**Item No.**                      **Report of the Head of Development Management and Building Control**

**Address:**                      77-79 HIGH STREET RUISLIP

**Development:**                Construction of 4 dwellings with associated stair and lift enclosure and landscaping.

**LBH Ref Nos:**                52931/APP/2023/3536

North-East Elevation

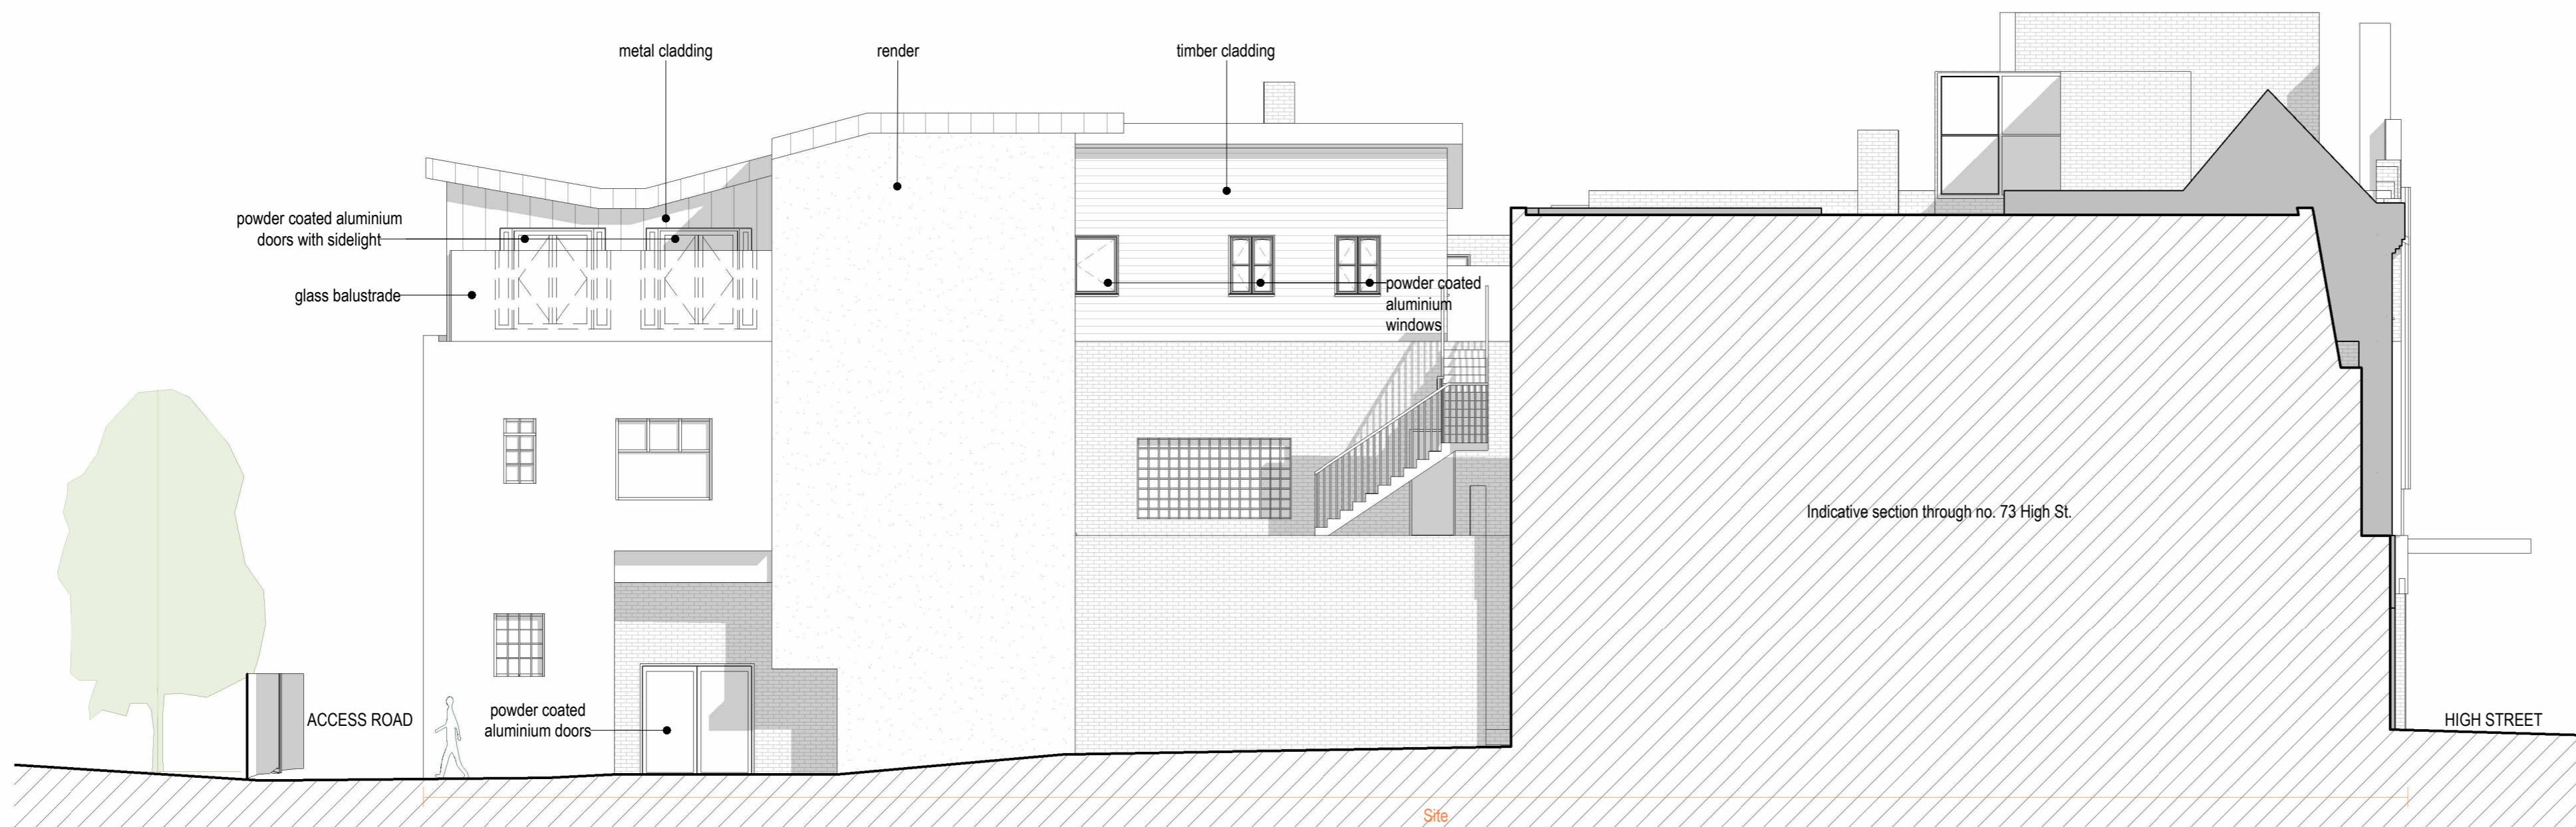
The proposed appearance is not supported as it is visually cluttered, lacks in aesthetic elegance, and is overly complex. The design fails to convey an overarching visual concept or idea, resulting in an incongruous appearance.

The circulation core is bulky, lacks any form of articulation and is blank in appearance, which makes it visually unattractive and poorly integrated. It is also a missed opportunity to create a distinctive feature that could 'announce' the entrance, adding both aesthetic value and functionality.

The proposed materiality palette is not supported. There is an excessive amount of closely located starkly contrasting materials in the proposed scheme which only contribute towards the visual clutter and the visual complexity of what should otherwise be a very simple back-of-house residential scheme. Cladding large areas in render, especially the primary entrance, is not supported in principle due to its lack of visual appeal, durability, and contextual relevance.
